23/05884/COND - 5 Grove Lane, Headingley

Landscape Comments

Comments are made with reference to photos and plans submitted 27/09/23 in relation to Condition 6 and 7.

Project No. SF 3188	Drawing No. TPP01	Rev. D
------------------------	----------------------	-----------

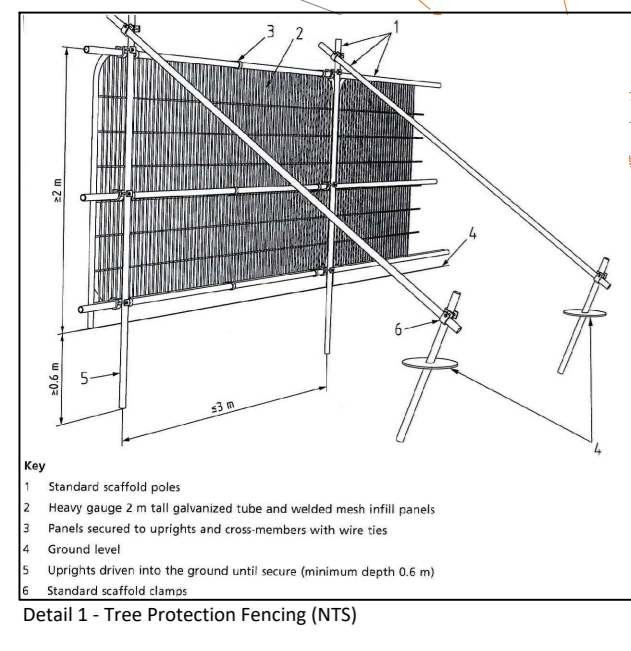
The TREE PROTECTION PLAN - TPP01 Rev B has been updated since the previous submission (dated 27/07/23) in relation to Condition 6.

The revised plan no longer illustrates the 'default' protection fence system with ground driven posts to prevent movement/displacement during construction operations. The alternative block tray system (which can be moved) is now illustrated based on the potential to encounter underground services. This easily moved system is not acceptable and service locations should be established and marked using standard methods with a utility locator. NOTE: This information is a requirement to discharge section (f) of Condition 7.

Given the large plant and construction vehicles accessing the site, ground protection should be illustrated within the root protection areas that occupy the driveway entrance, to prevent localized compaction, intercept spillages etc. Please add.

Previous comments stated the TREE PROTECTION PLAN should illustrate tree numbers and the AMS should include an 'on-site monitoring schedule' for the development phase that includes the requirement for site visits at key stages and on-site supervision for specific arboricultural operations (fence/ground protection installation, excavation within RPA's etc.). All in accordance with section 6.1.2 of B.S 5837:2012.

The discharge of Condition 6) cannot be recommended at this time.

TREE PROTECTION - PHOTOGRAPHS OF TREES WITHIN THE TPA

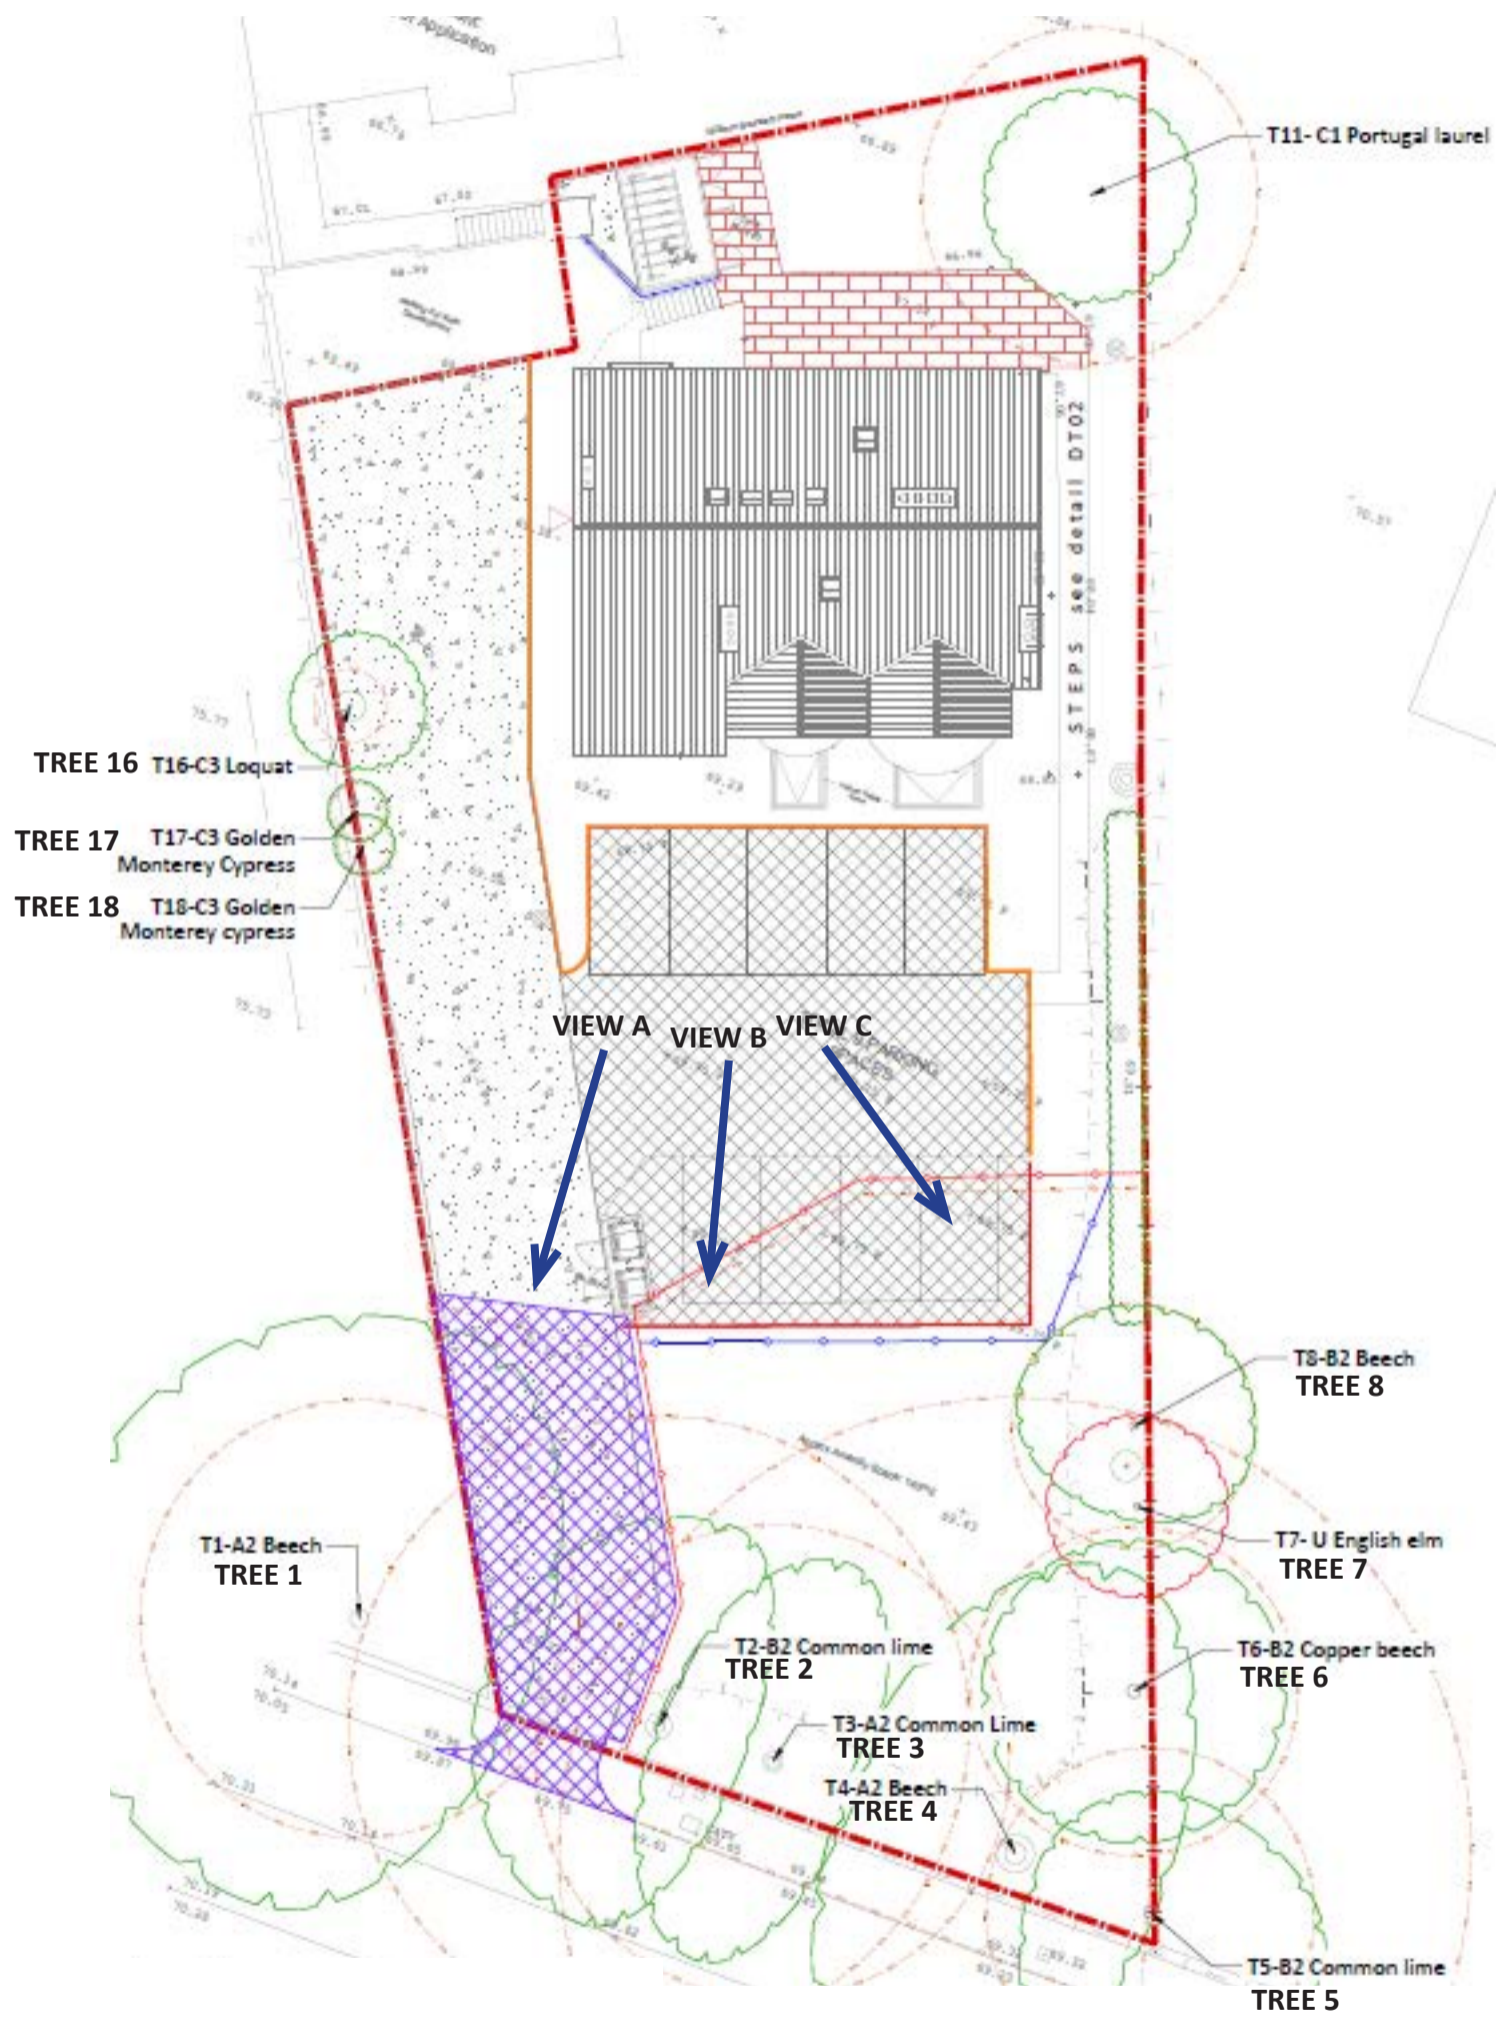
Previous comments also advised that the photographic evidence provided should label trees and indicate the direction and location of the image taken, with canopies visible. The current photos do not offer this information. They do, however, indicate sections of fence that are not connected (overlapping) and the storage of materials within protected areas (see image below), which is forbidden in accordance with section c) of Condition 6: *'No equipment, machinery or materials shall be used, stored or burnt within any protected area'*.

Project No. SF 3188
Drawing No. L101

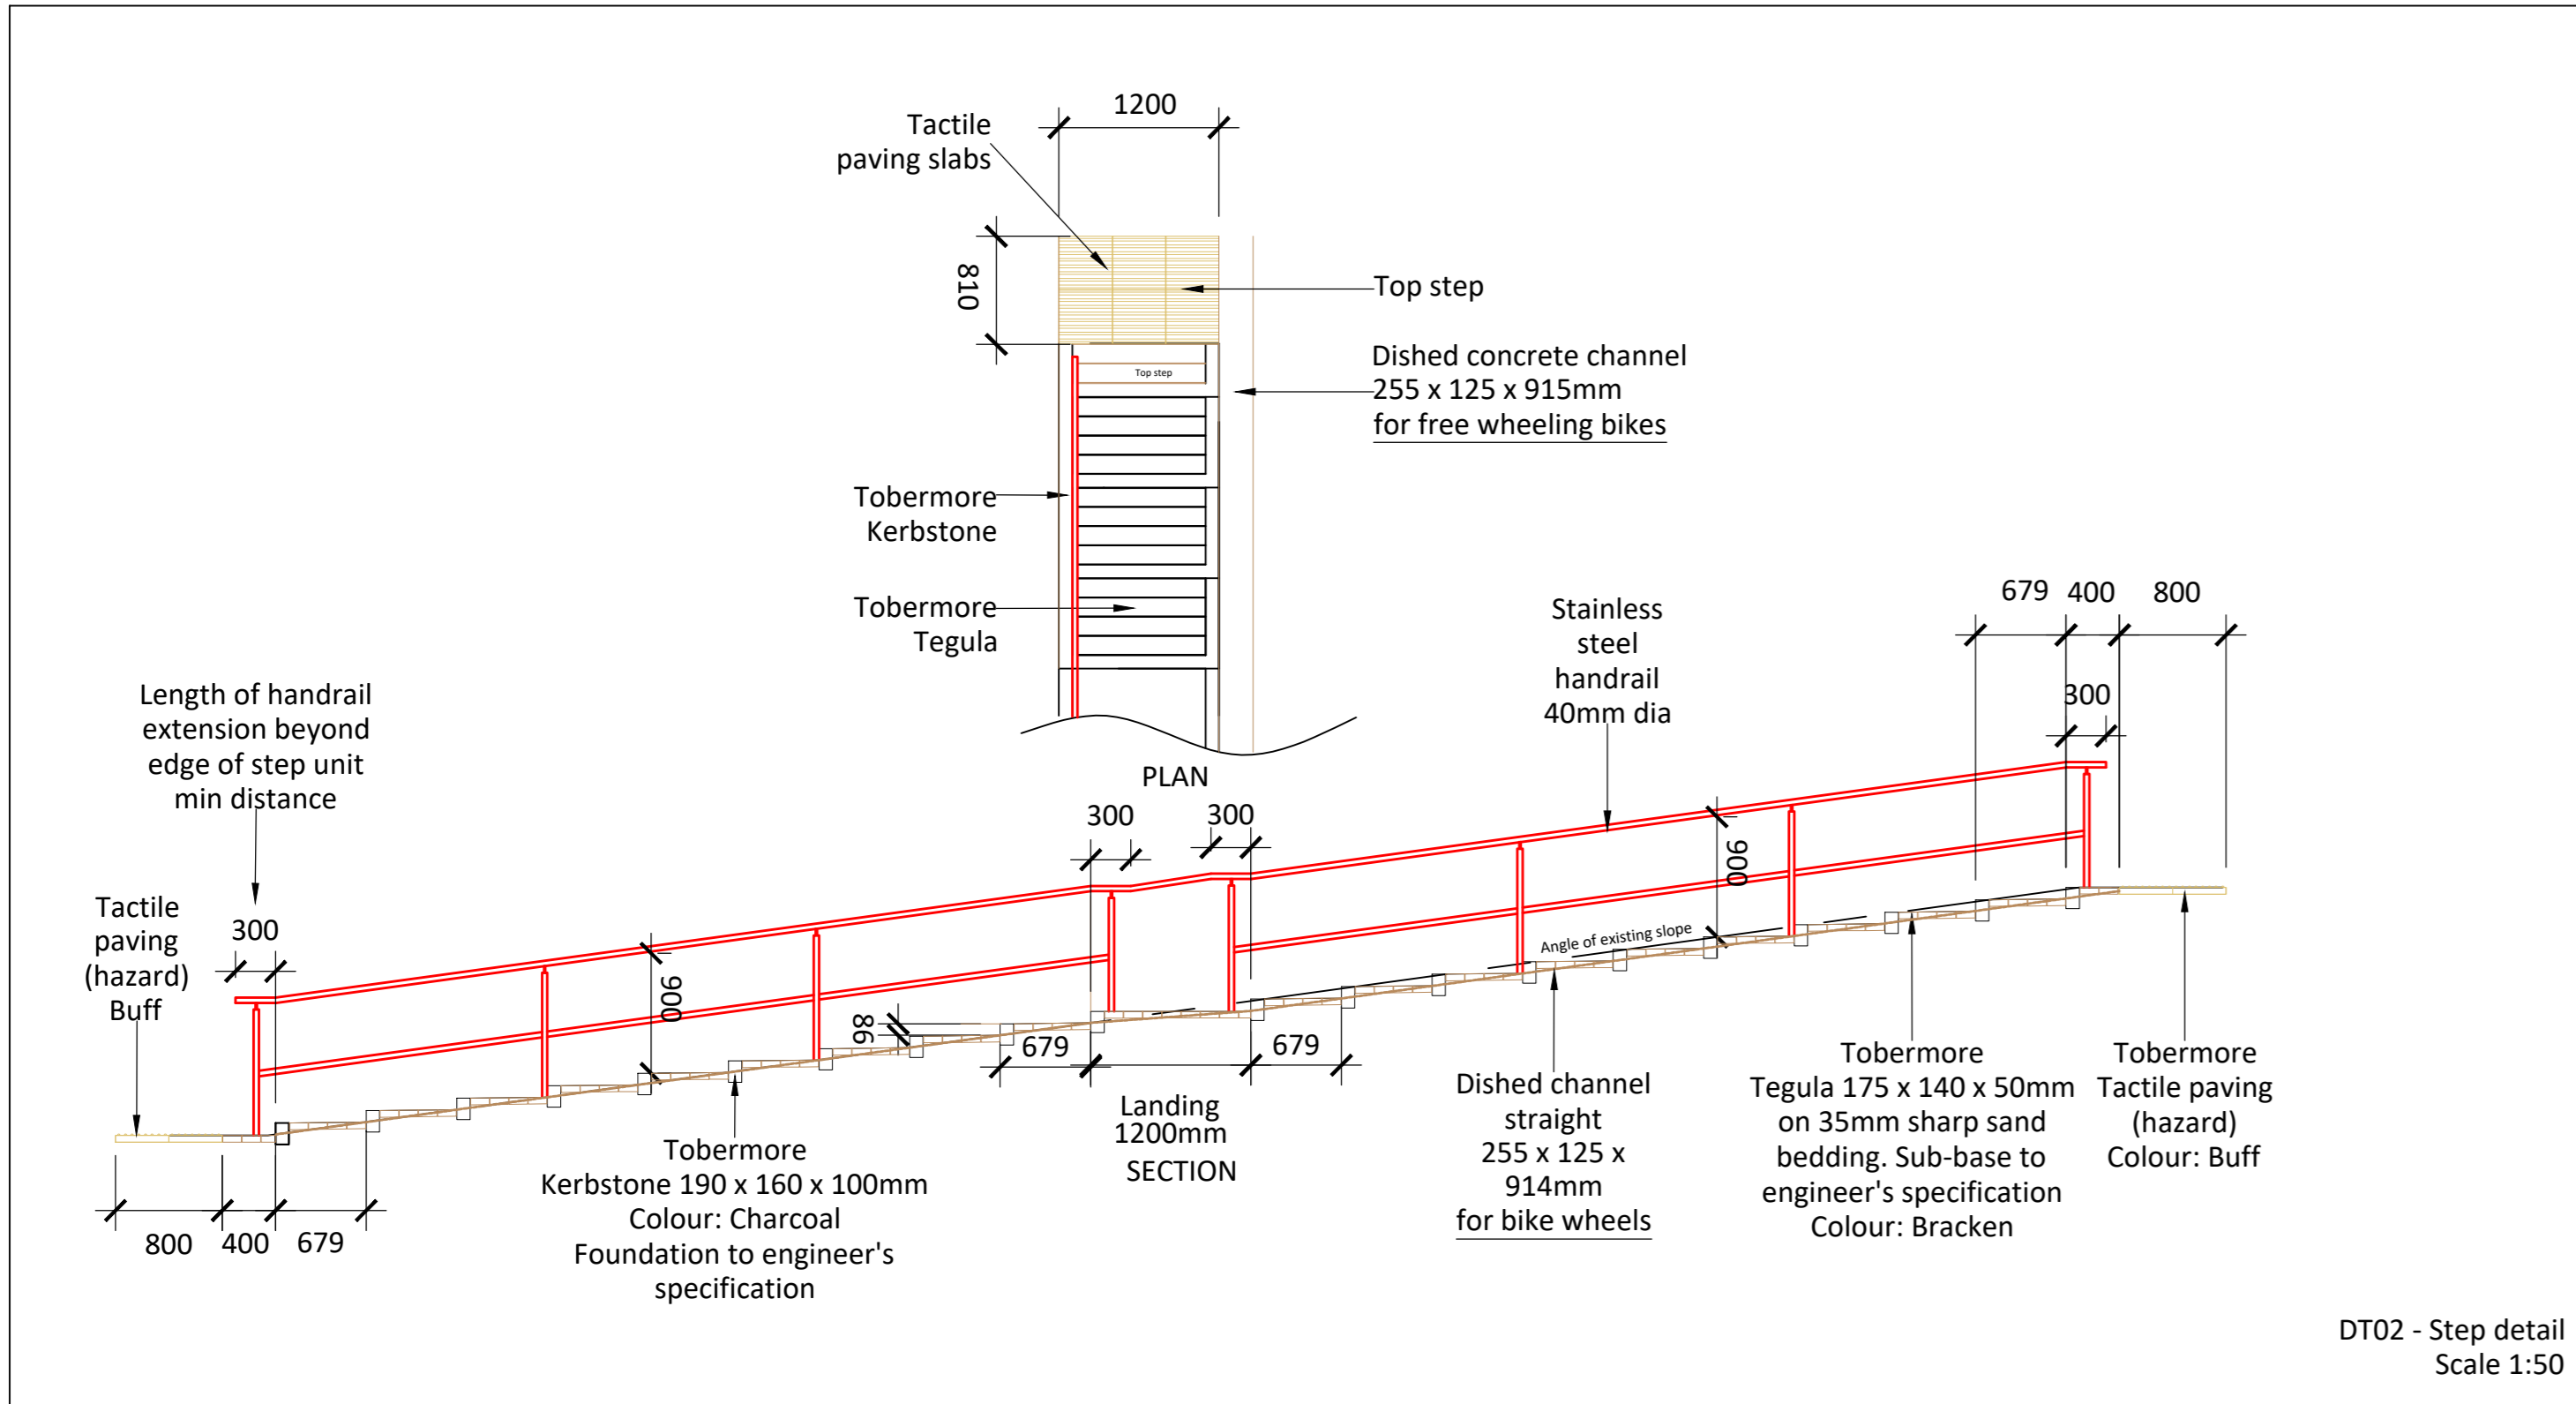
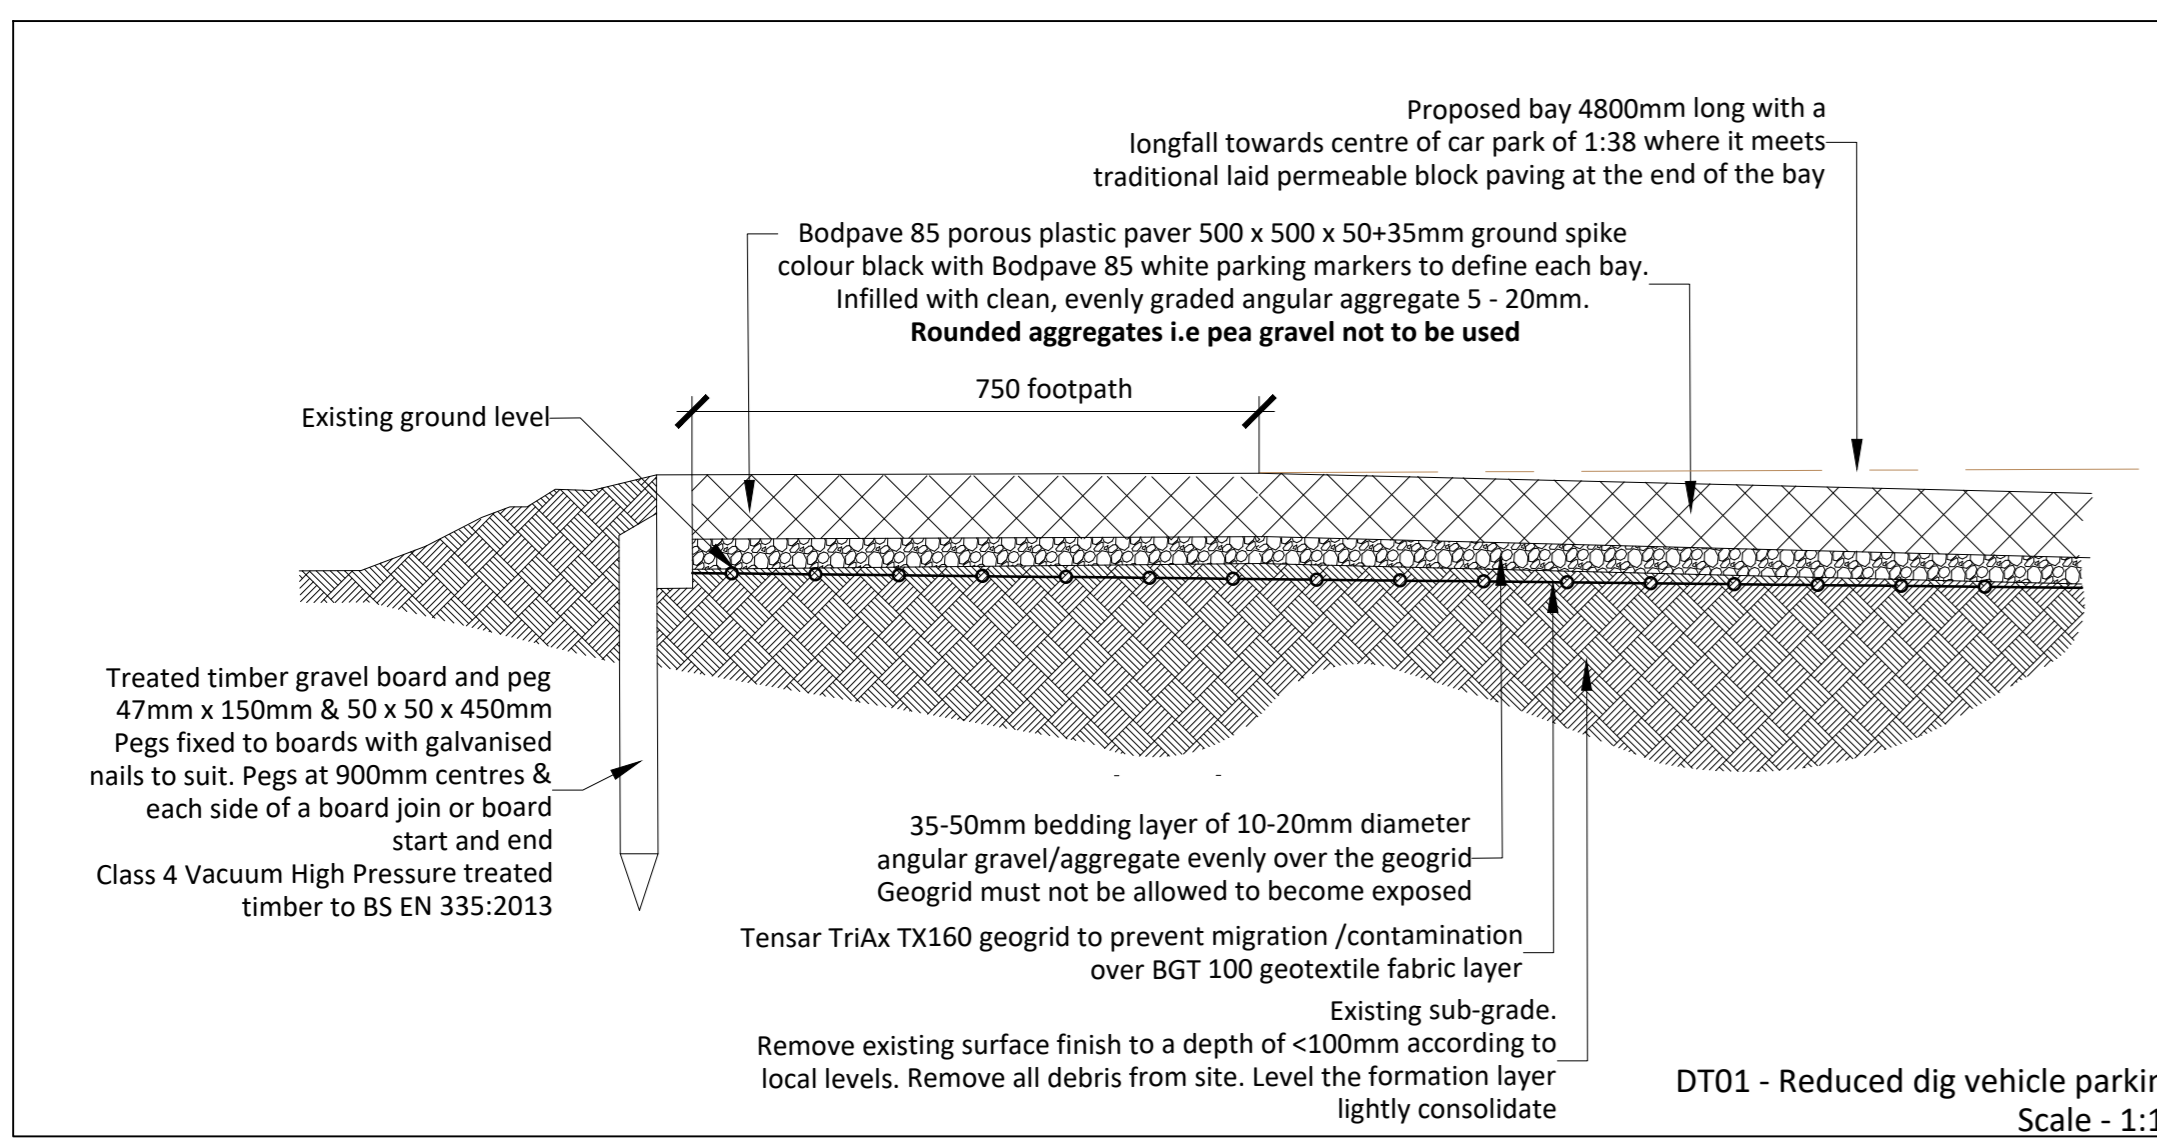
HARD DETAILS relating to proposed steps do not illustrate widths or accessibility in accordance with Part M. Given access to the rear cycle store is via steps, there must be enough space to carry a cycle. The width appears to be 900mm? Please demonstrate/confirm part M compliant access.

Please illustrate proposed preservative staining treatment to timber screens and services alignments above and below ground.

SOFT DETAILS should accord with the LEEDS PLANTING CHECKLIST:

<https://www.leeds.gov.uk/planning/conservation-protection-and-heritage/landscape-planning-and-development/planting-checklist>. Please display below ground utilities on landscape plans, provide all shrub planting densities, specify peat free compost, etc.

Plans should illustrate any level changes as previously requested. Please confirm by illustrating existing and proposed levels in the vicinity of tree roots.

The discharge of CONDITION 7 cannot be recommended at this time. Please submit the additional information outlined above.
